Application for Planning Permission

Development: Retention of 3 No. flats as previously approved under BR/162/20/PD. This application is in CIL Zone 4 (Zero Rated) as flats.
Location: 34 Sudley Road Bognor Regis PO21 1ER

Floor Plan

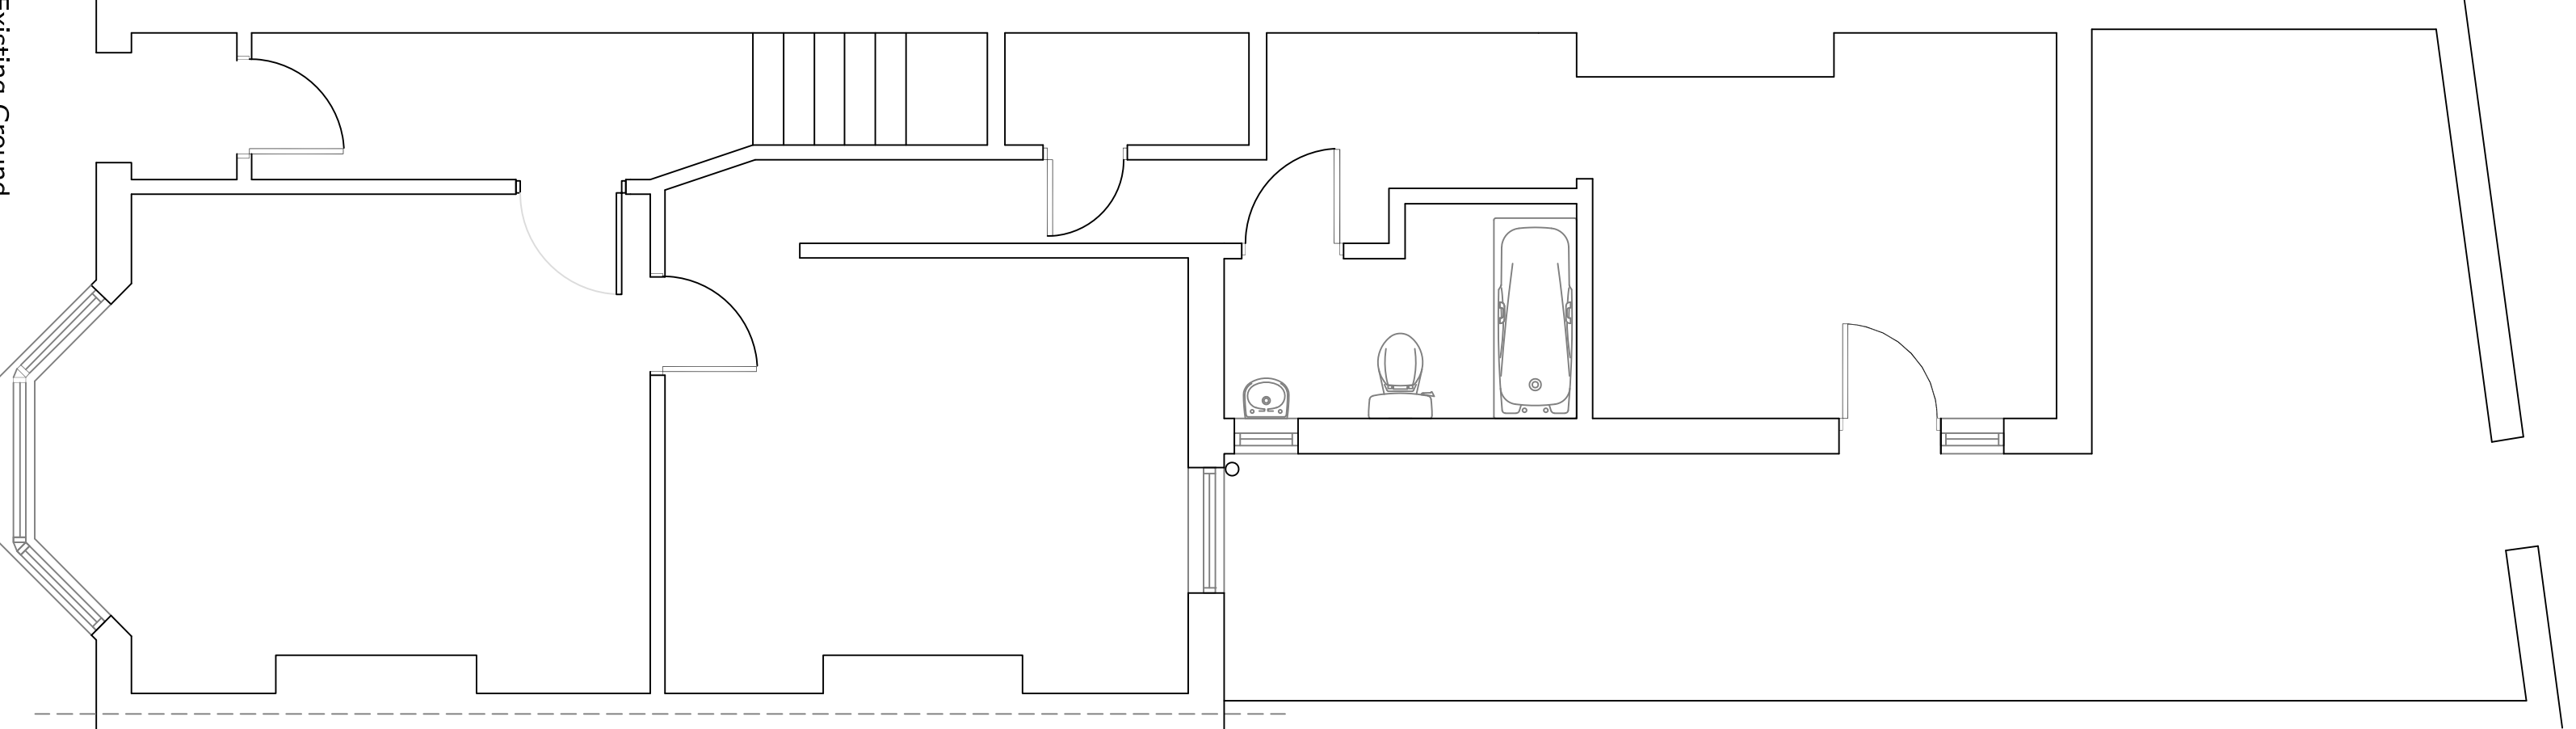
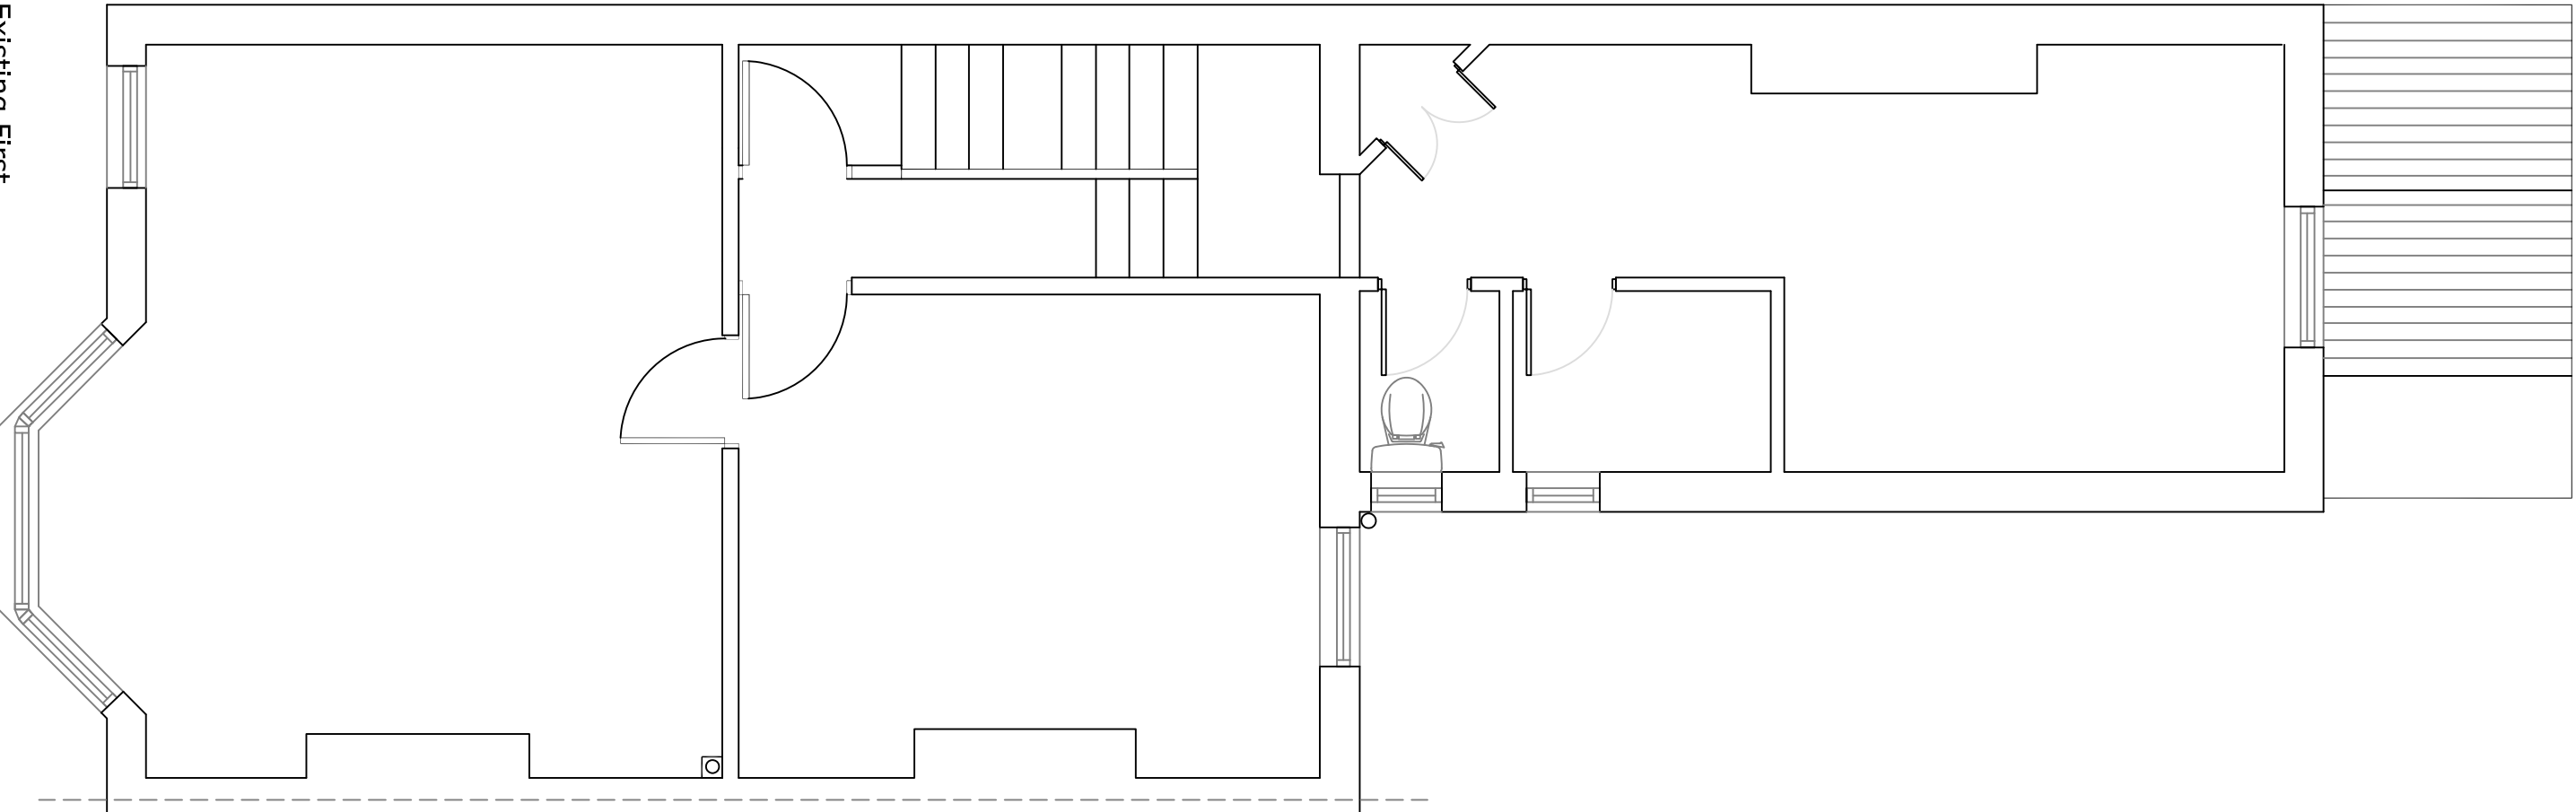
On proposed ground floor plan there is a window on the east elevation (bathroom) but it is not on the proposed east elevation plan, please amend.
